12255
8 June 2017

**SECTION 96(2) MODIFICATION APPLICATION SSD 7388 – MOD 3
31 WHEAT ROAD, SYDNEY**

On behalf of Grocon (Darling Harbour) Developments Pty Ltd we hereby submit an application pursuant to section 96(2) of the *Environmental Planning and Assessment Act, 1979* (EP&A Act) to modify SSD 7388 relating to The Ribbon development (former IMAX site).

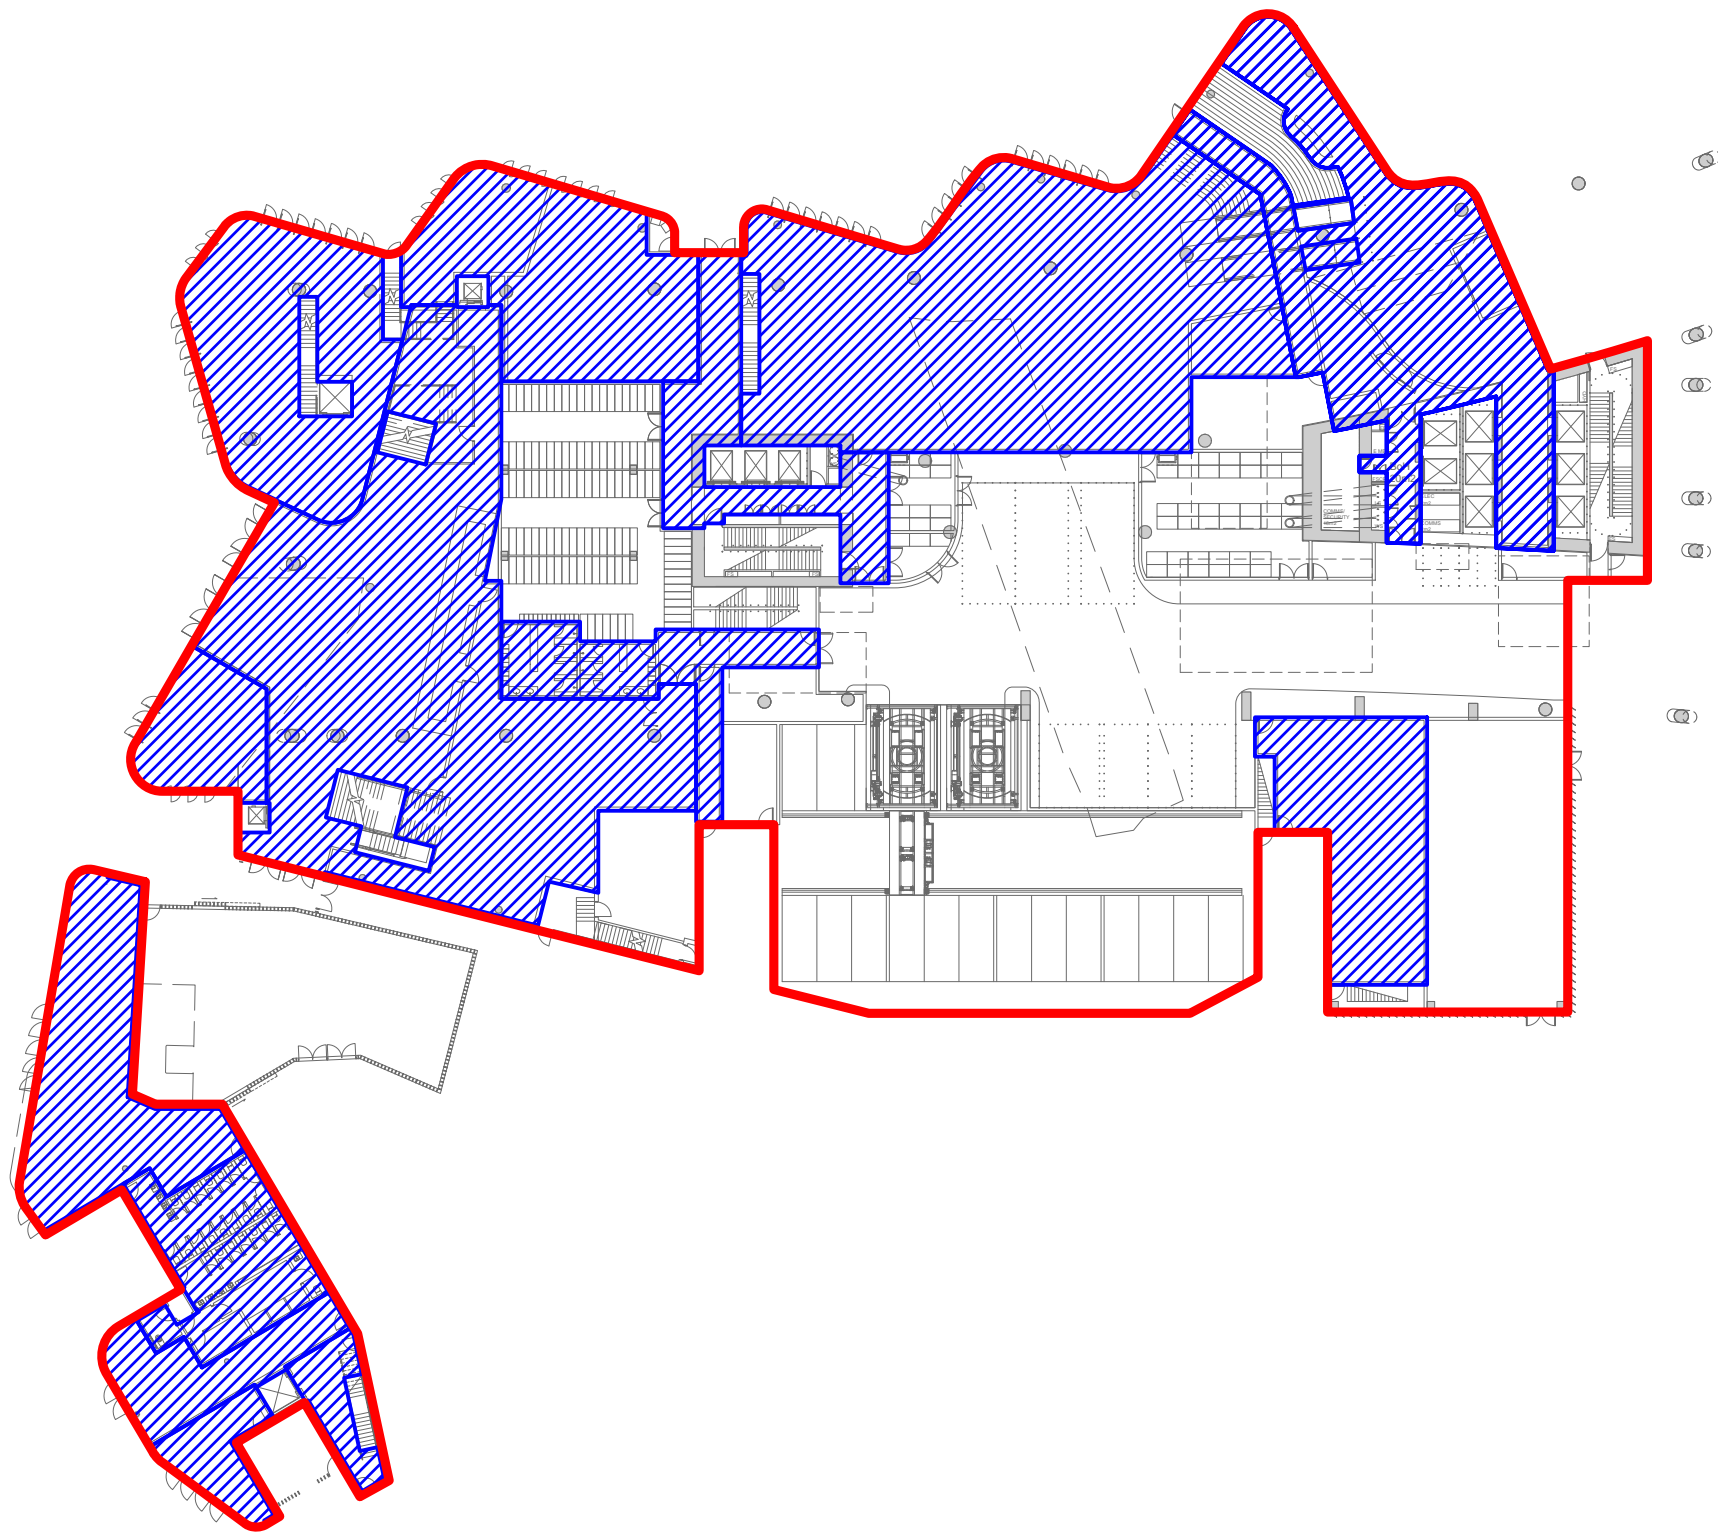
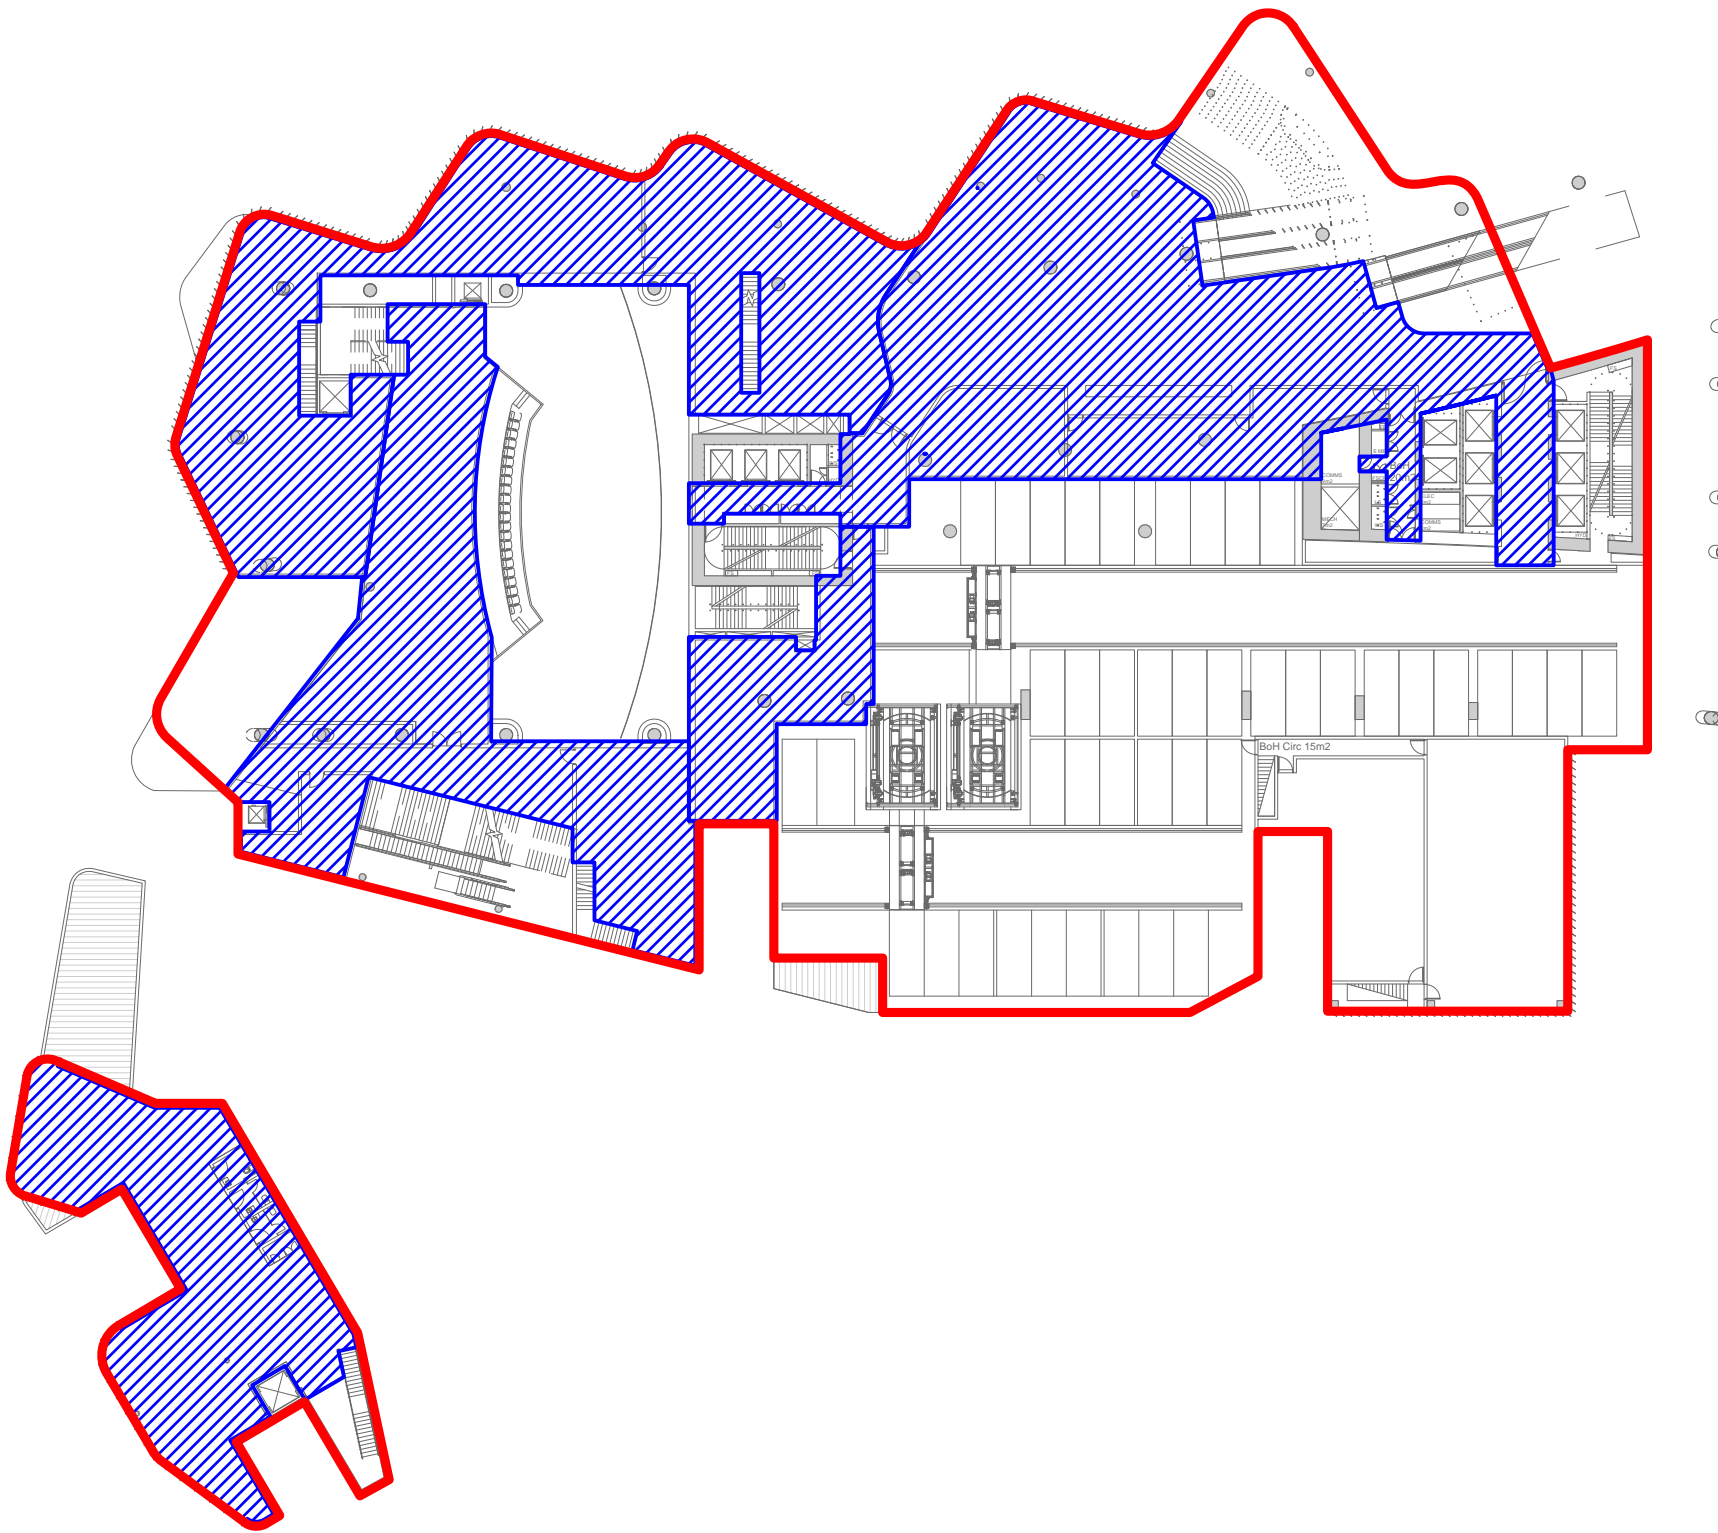
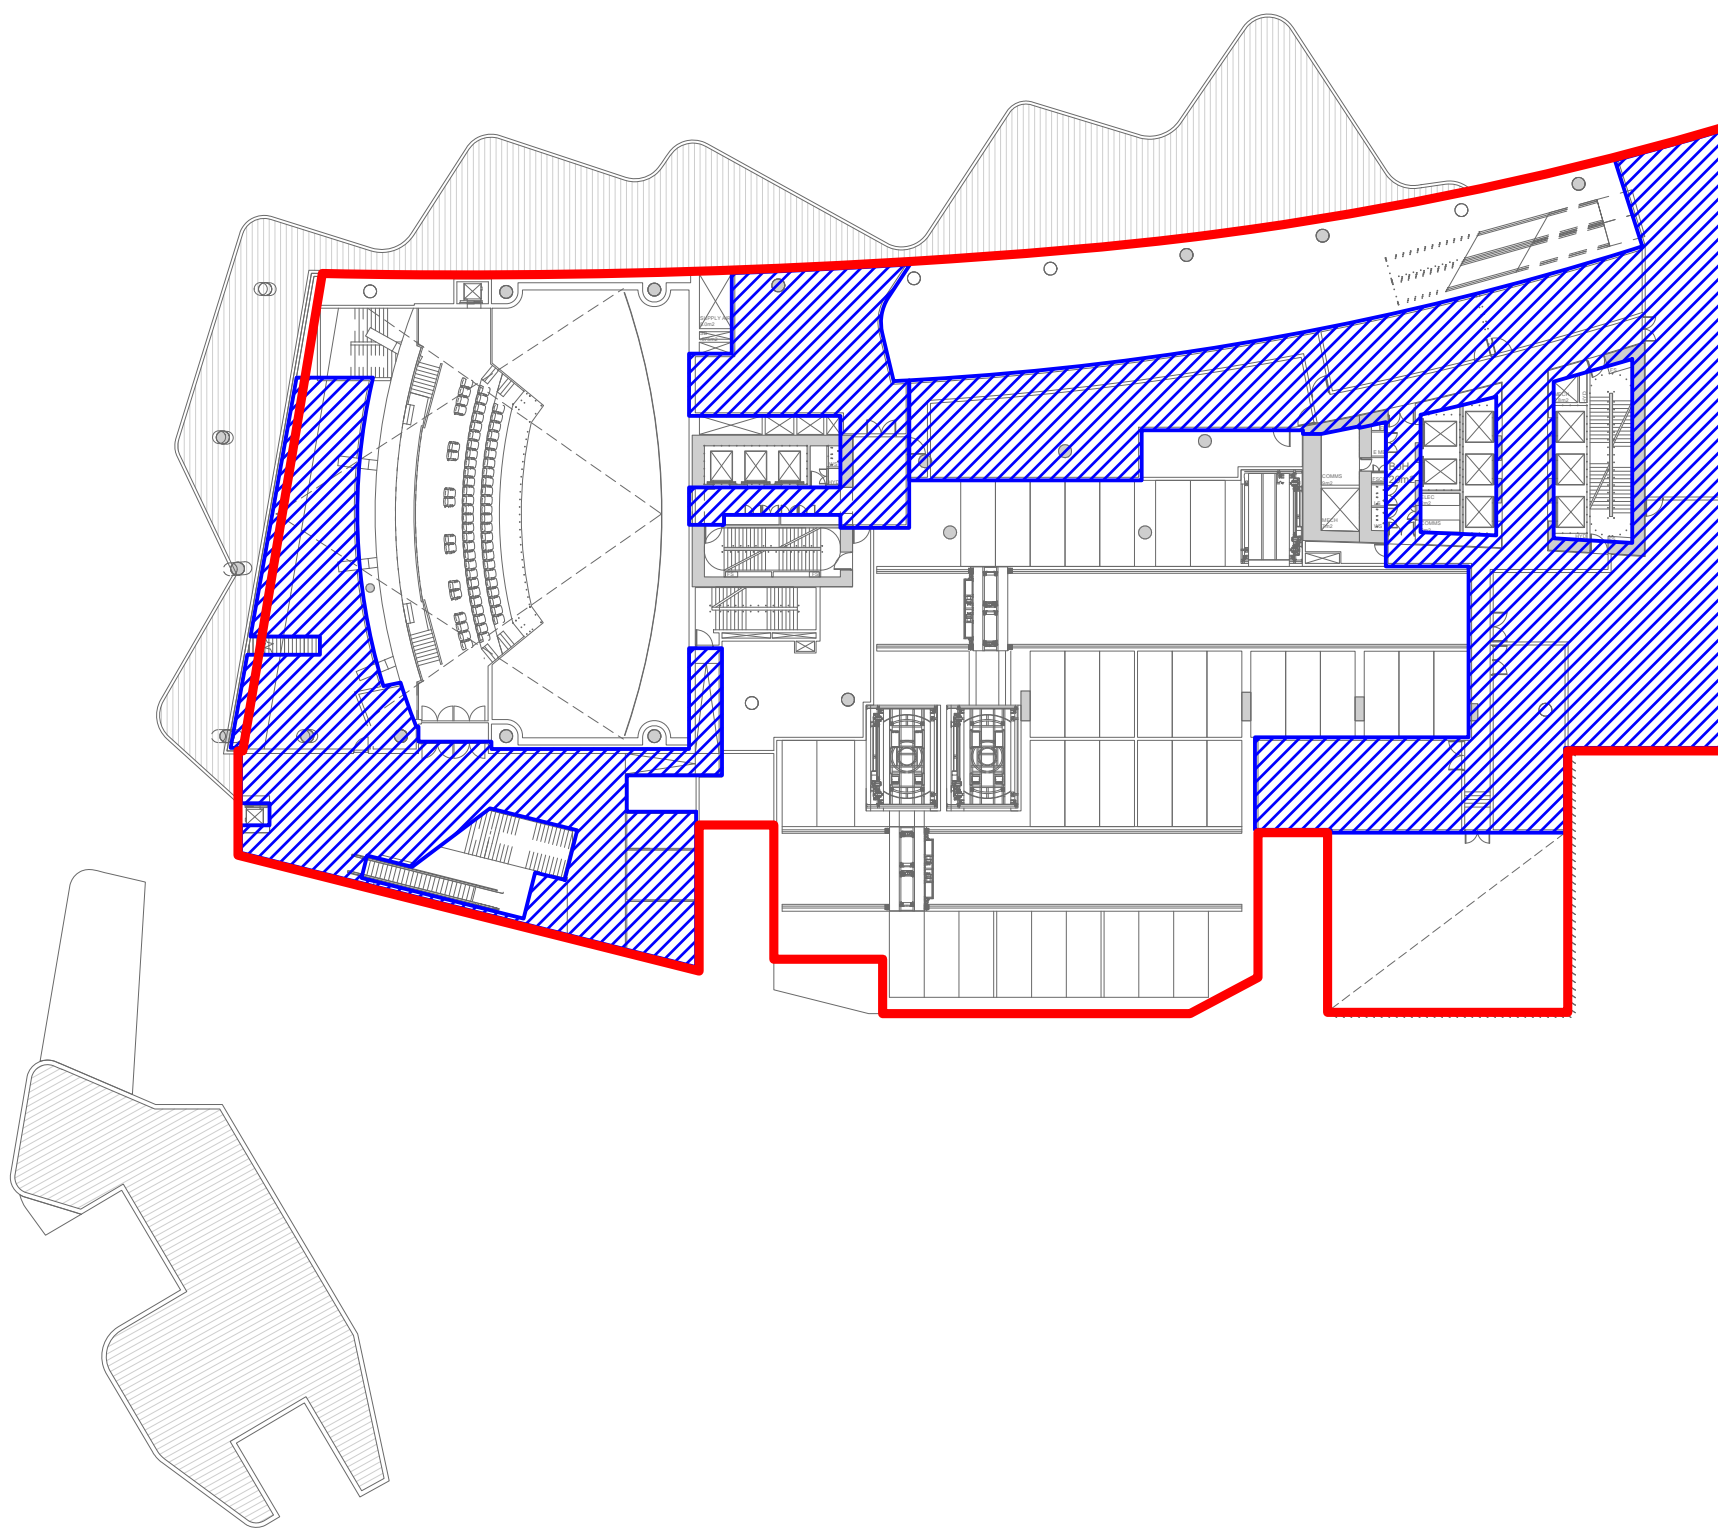
The revision of the building envelope necessitates the reconfiguration of the retail tenancies within the podium. The revised layout is shown in **Figure 2**. The proposed amendments increase the gross floor area(GFA) of the development by 107m² refer to the GFA calculations on drawing ARC-HSL-DD-SK-532.1.
